Messing and Inworth Action Group

A12 Chelmsford to A120 Widening Scheme

Application for Development Consent Consultation on proposed changes to the draft Development Consent Order Application.

Reference; TR010060/Change Application Letter

Map Book 4: B1023 Flood Mitigation and Drainage

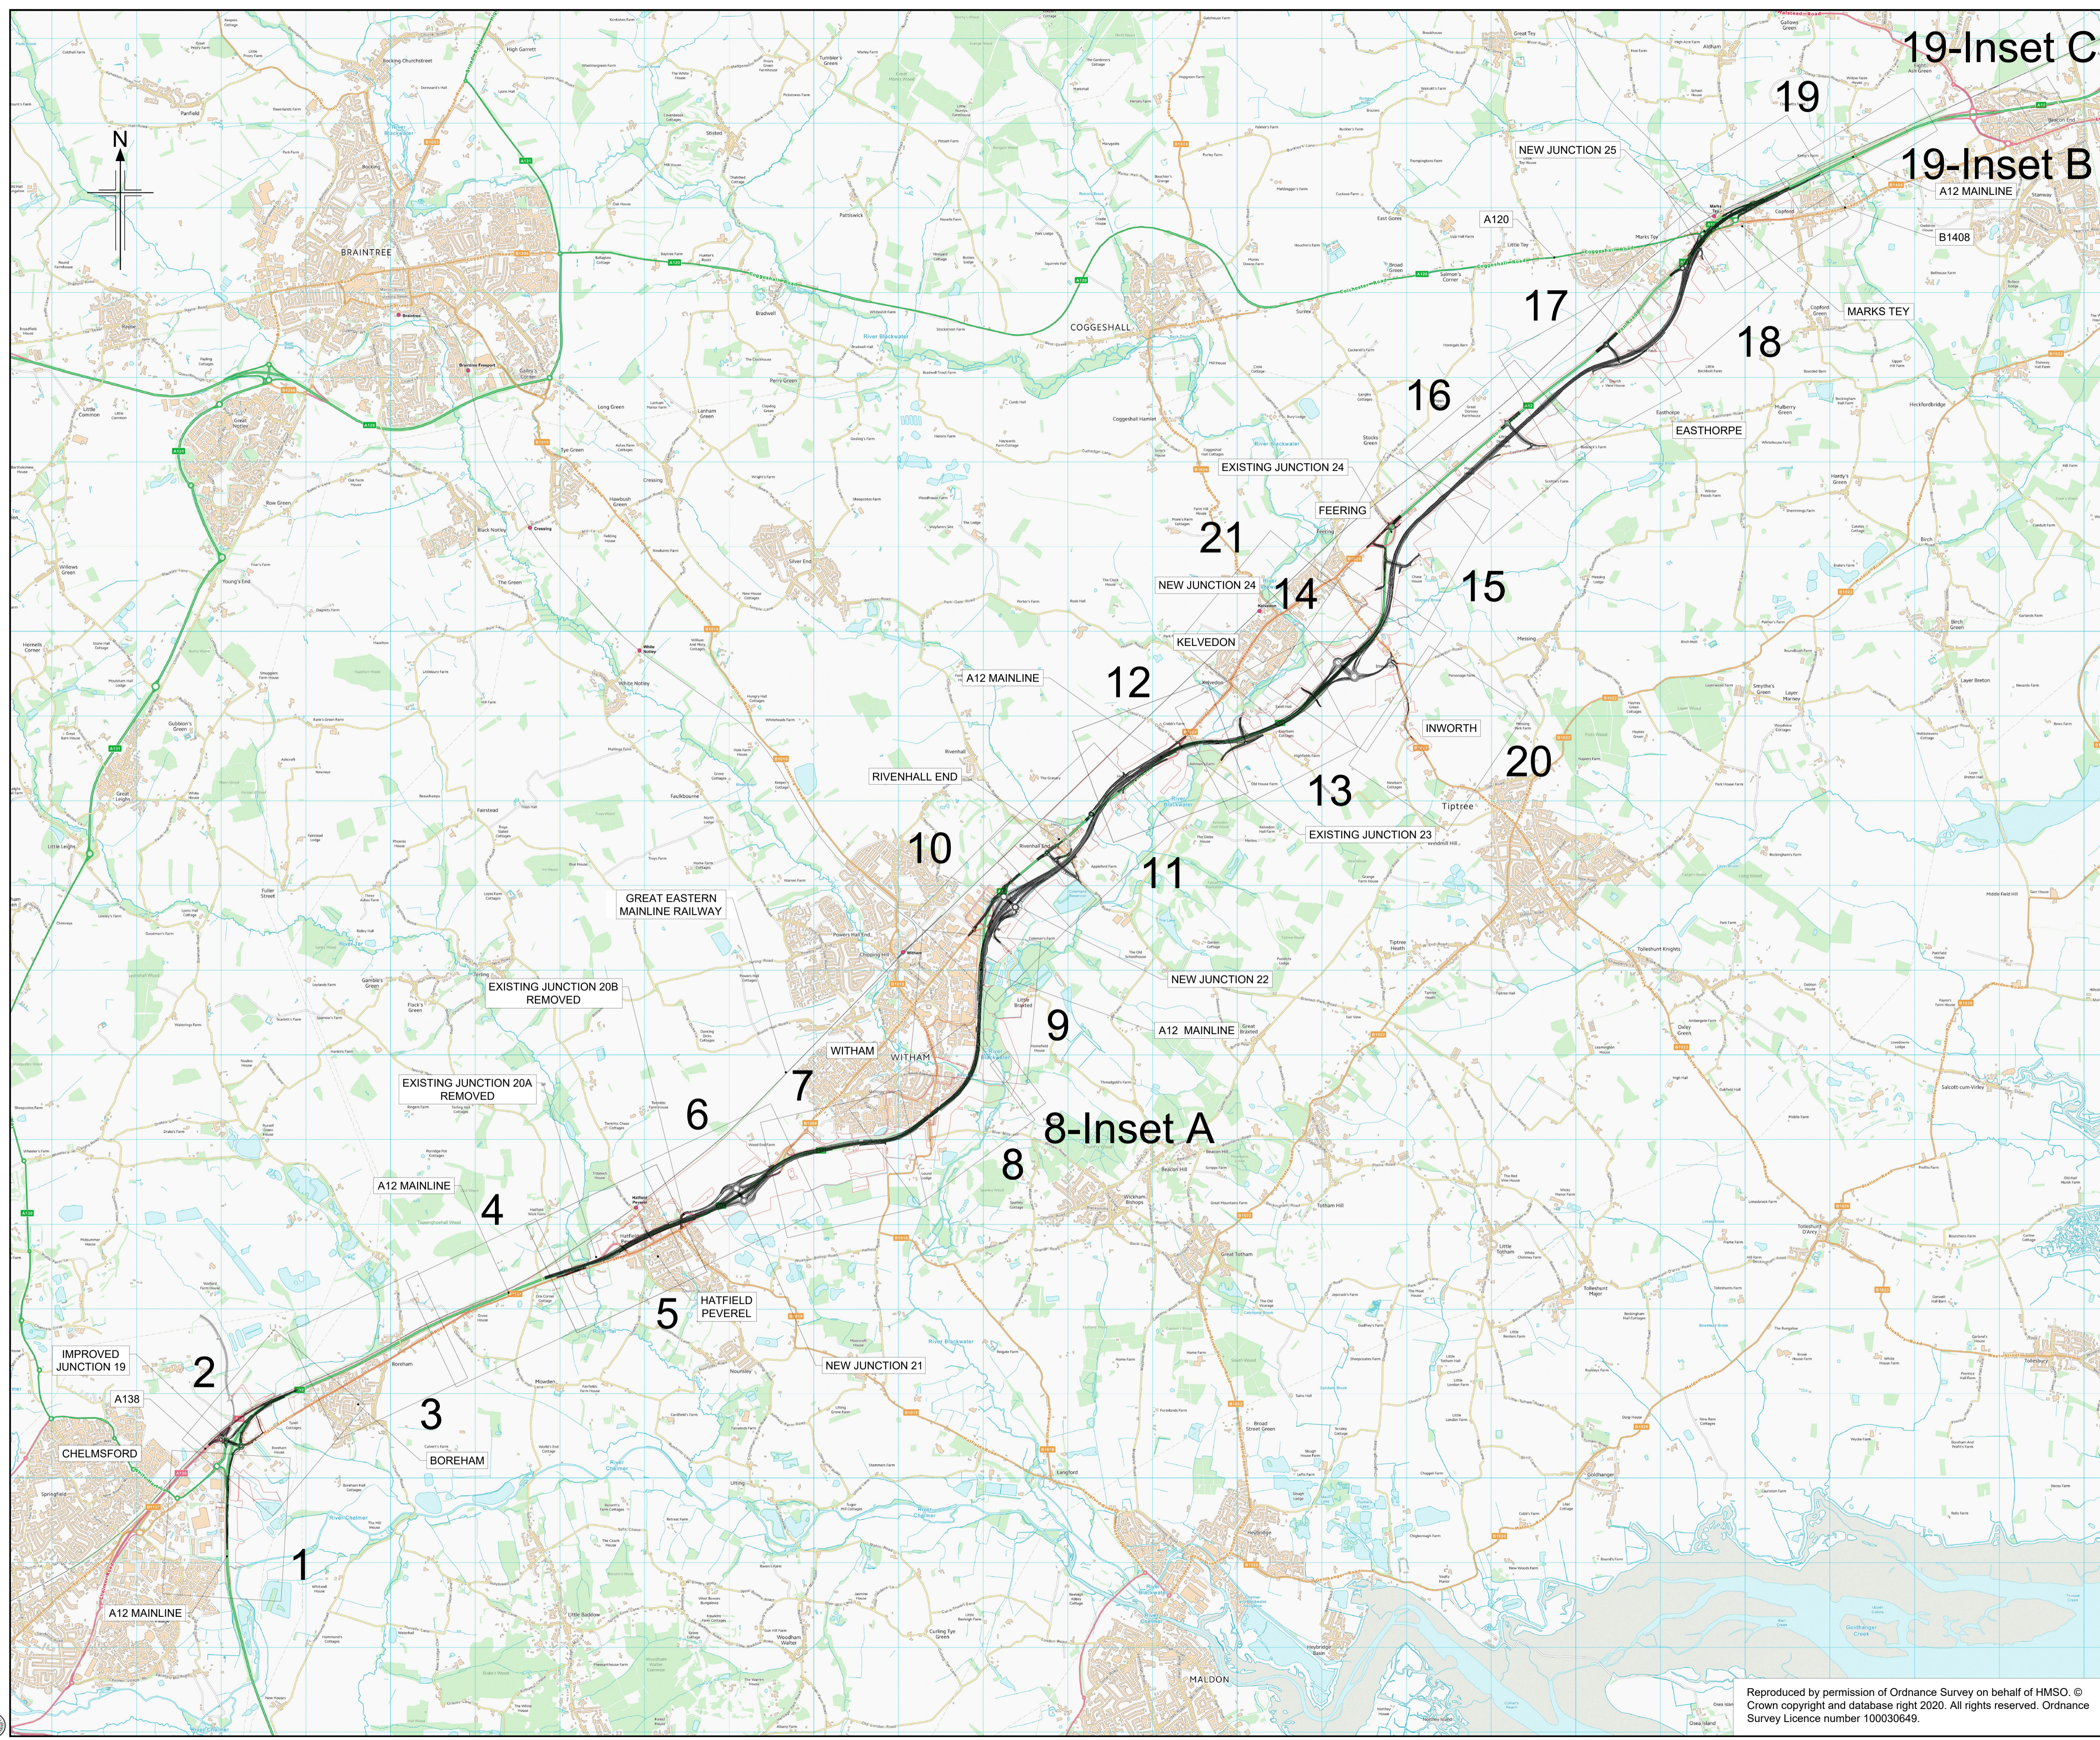
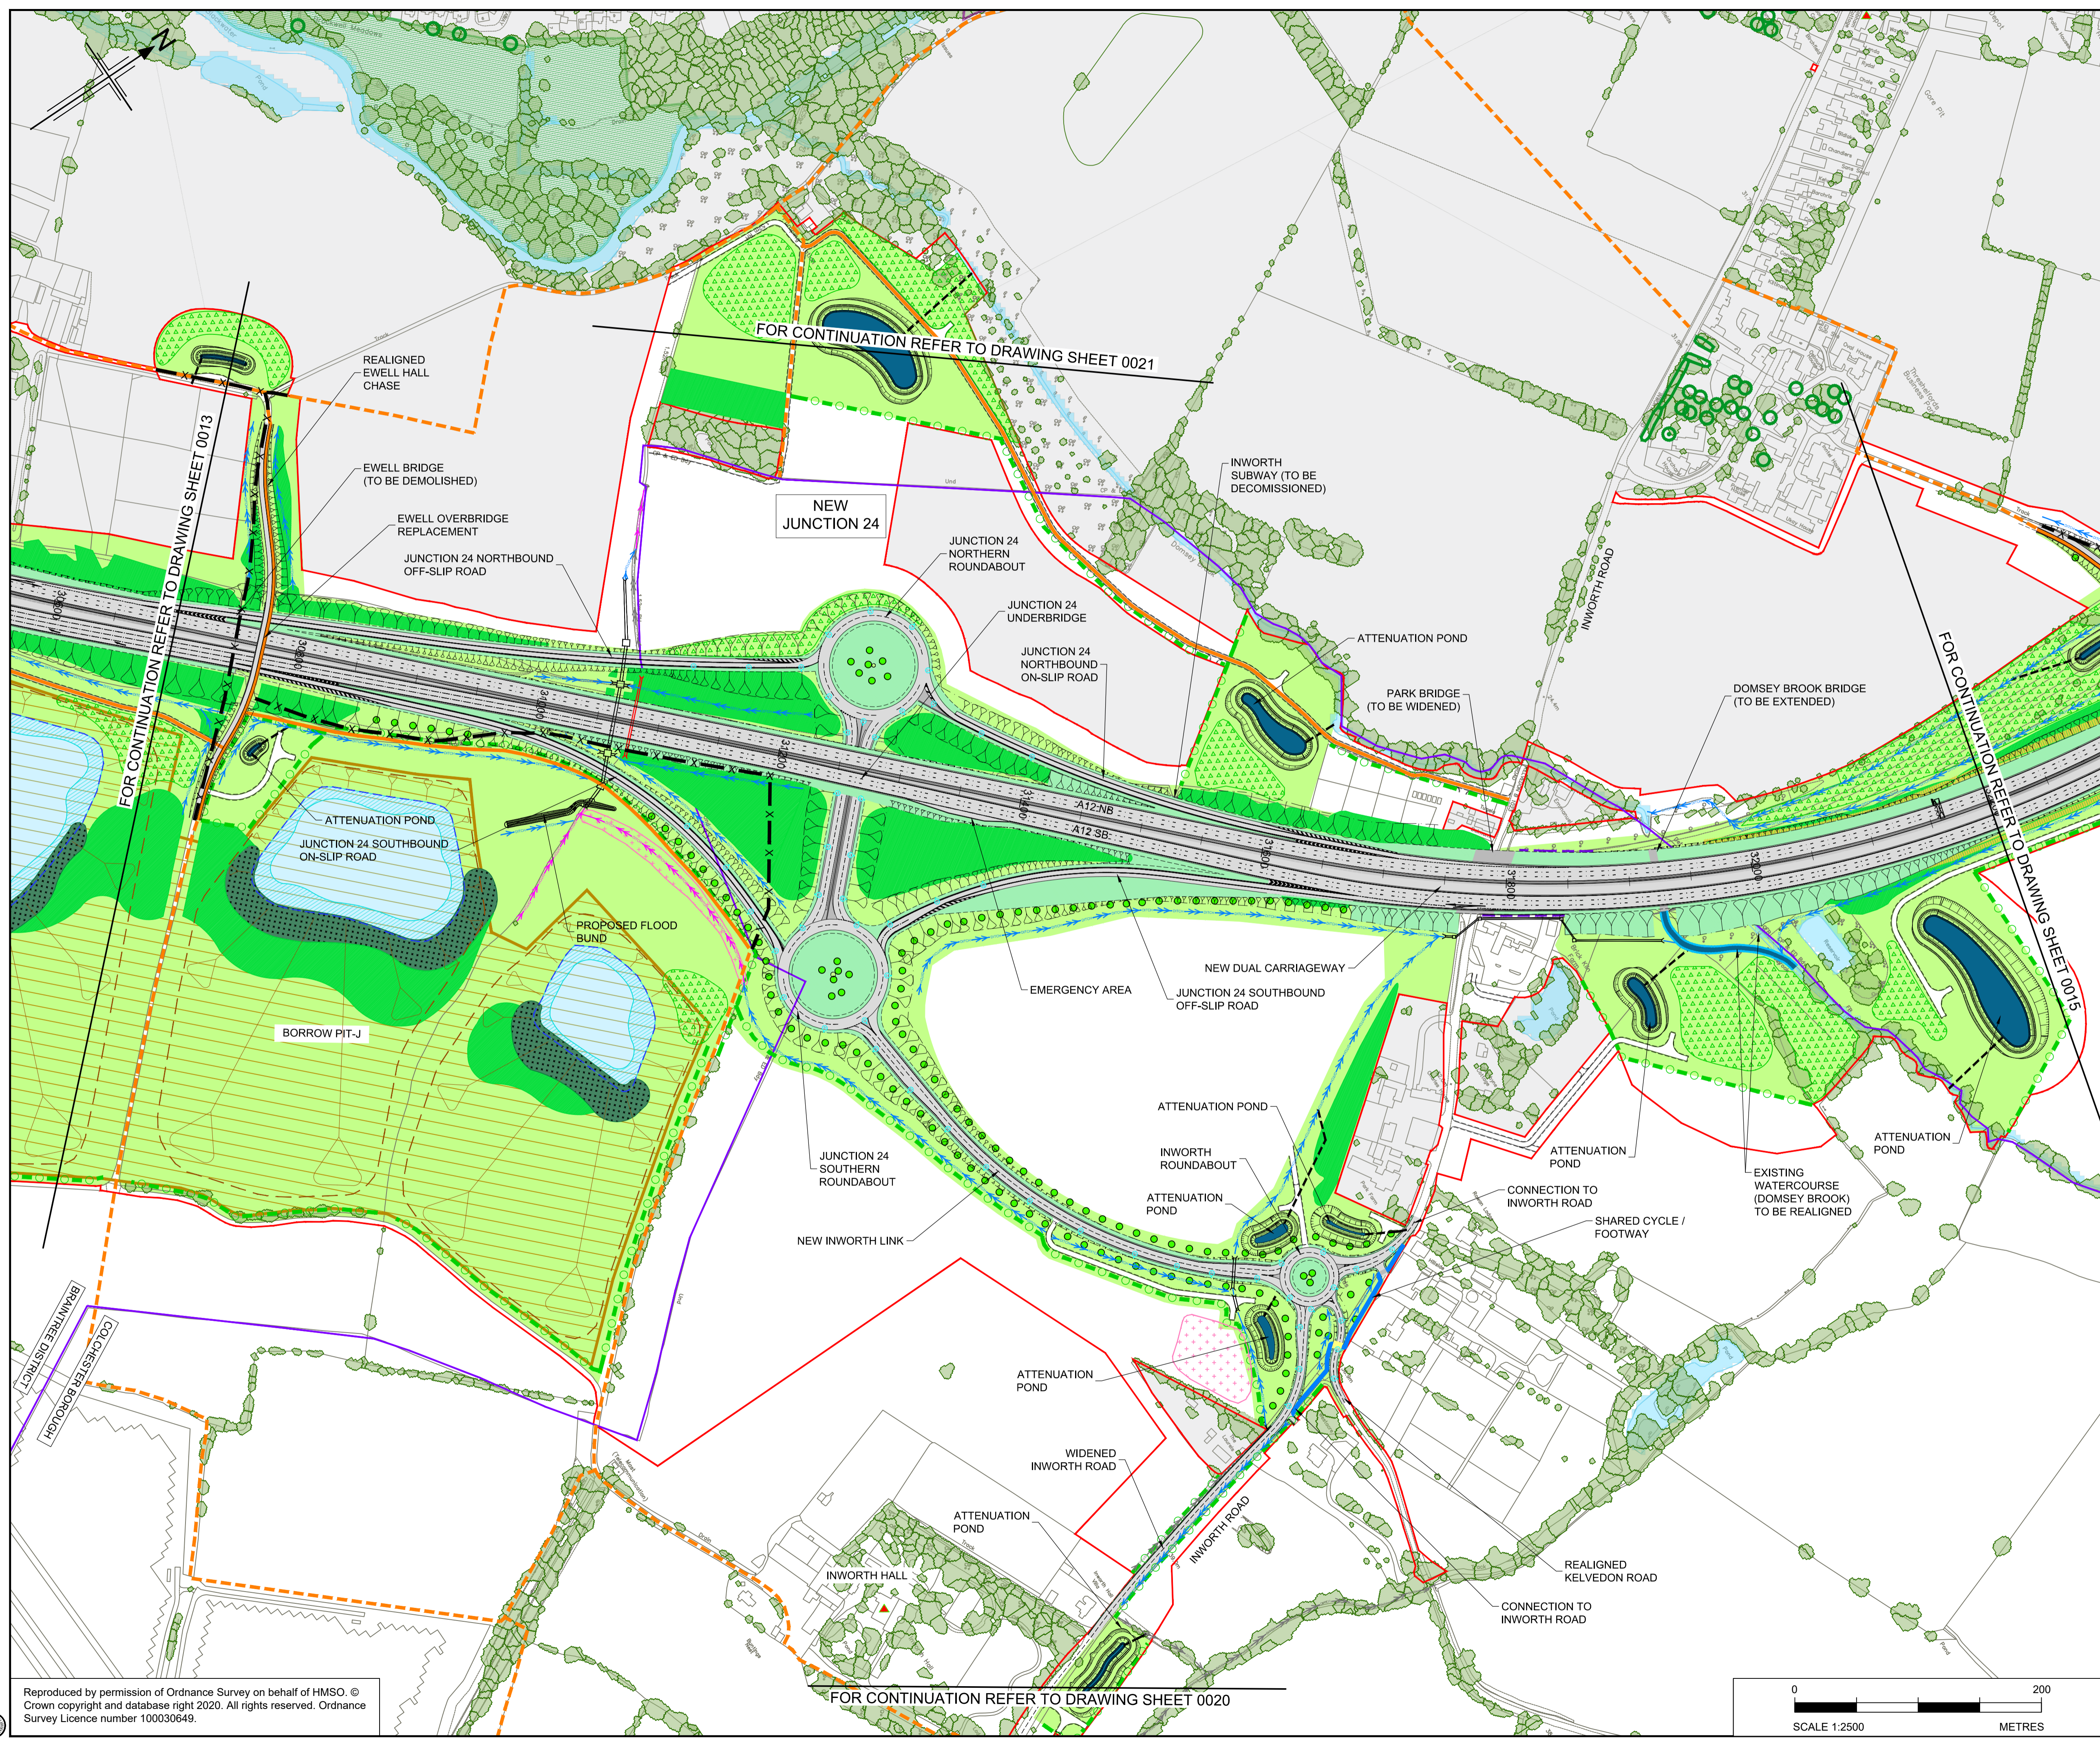
MIAG is aware of this constant confirmation bias in all the actions of the Applicant, and requests clarification and justification for a proposed fifty per cent reduction (4 to 2) in Drainage Ponds and a reduction of just under fifty percent (in quantum) of Flood Mitigation Areas?

The reduction in size of the 2 of the remaining ponds is also challenged as effectively creating over fifty percent net in reduction in this mitigation. This is of such substantial scale as to be questioned in the original design, and that reliance on those original surveys calls into question all subsequent statistics and designs based on erroneous input.

This is simply diagrammatical illustrations of what the Applicant proposes. It serves no other purpose than to justify a decision the Applicant appears to have before any 'consultation'. See extensive written representations from stakeholders including MIAG about all 'consultations' undertaken by the Applicant and all breaches associated thereto.

It is of note that the Applicant uses as justification the 'reduced impermeable pavement' which means that mitigation can be equally reduced. However, in direct contradiction of this, the Applicant also notes there is 'only a slight decrease in the final footprint'. This is contradictory and false justification used to enforce the confirmation bias from the Applicant.
